Addendum No. 1

RE: Contract # C203782

I-40/I-85 From East Of The Guilford County Line To 0.2 Miles

East Of NC-54 in Graham

Drawing file: 200 Transportation Management Plans / 200_100_I-5309_5836_TMP-18.pdf

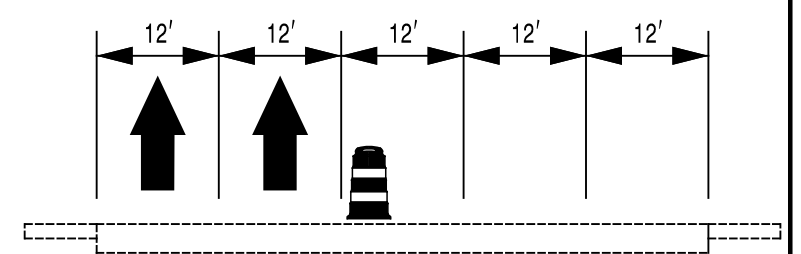
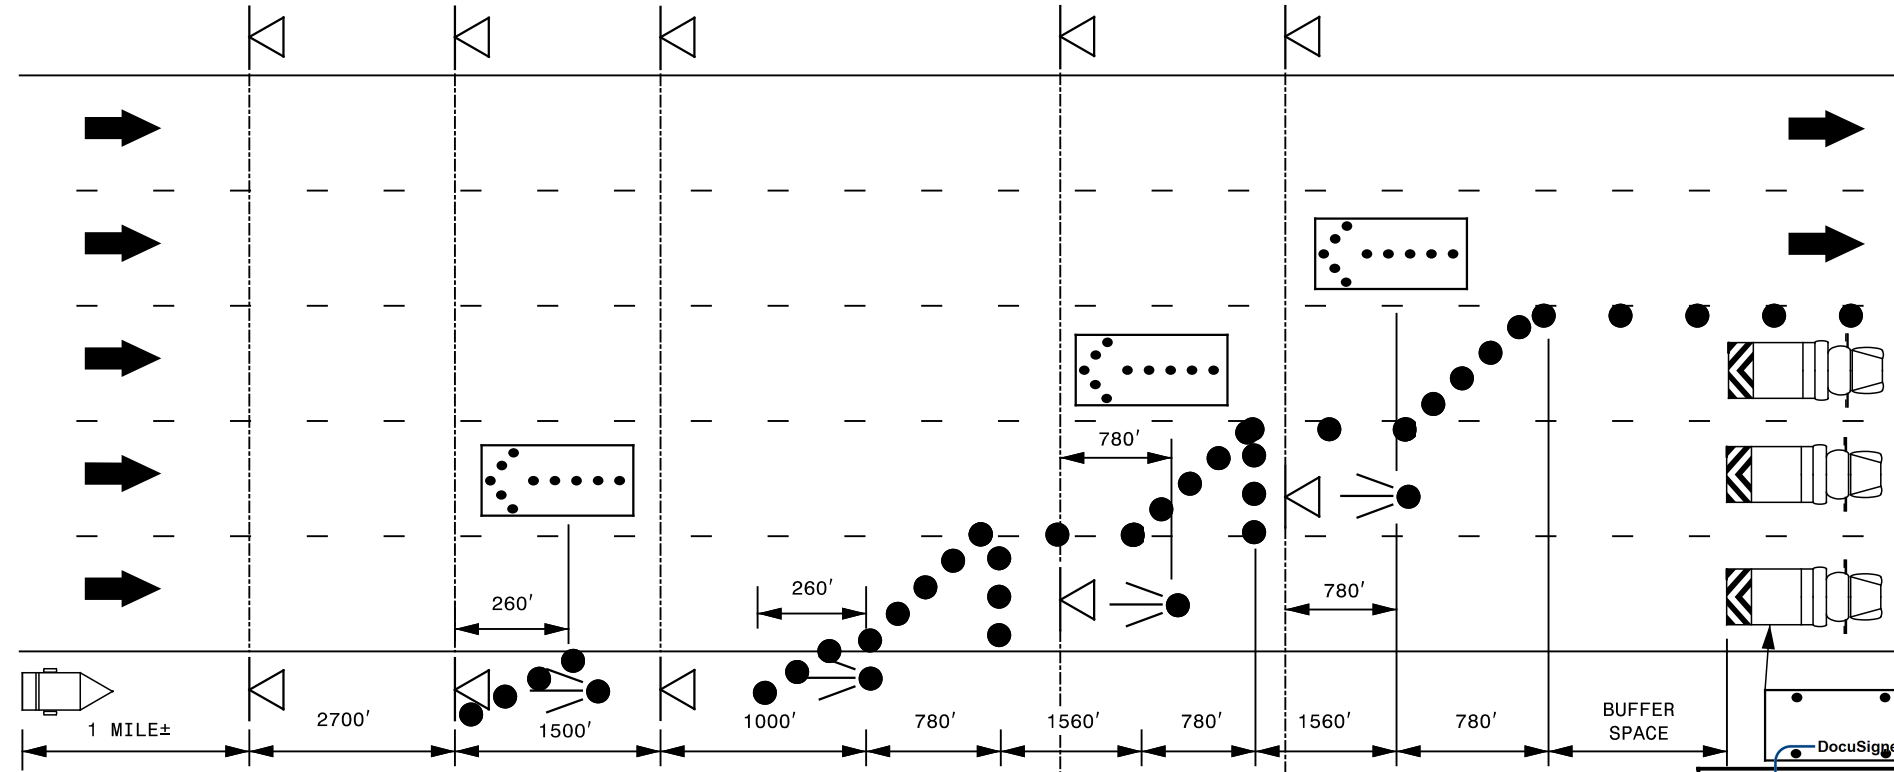
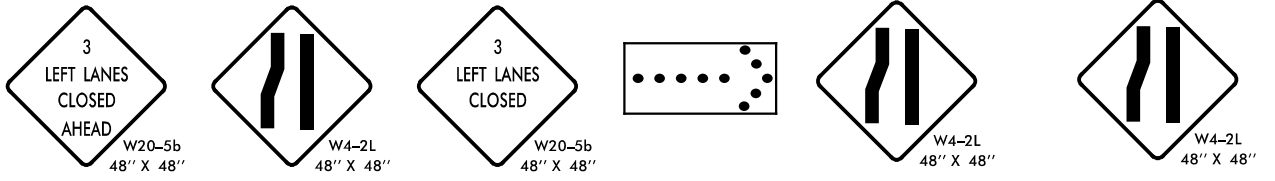
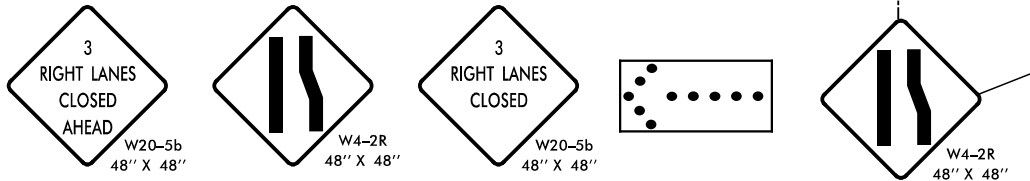
Sheet No.	Revisions
6 thru 9	Revised to reflect the below noted quantity changes and pay item additions
TMP-1B and TMP-1C	Revised to reflect the changes in the Intermediate Contract Times in the proposal as mentioned below
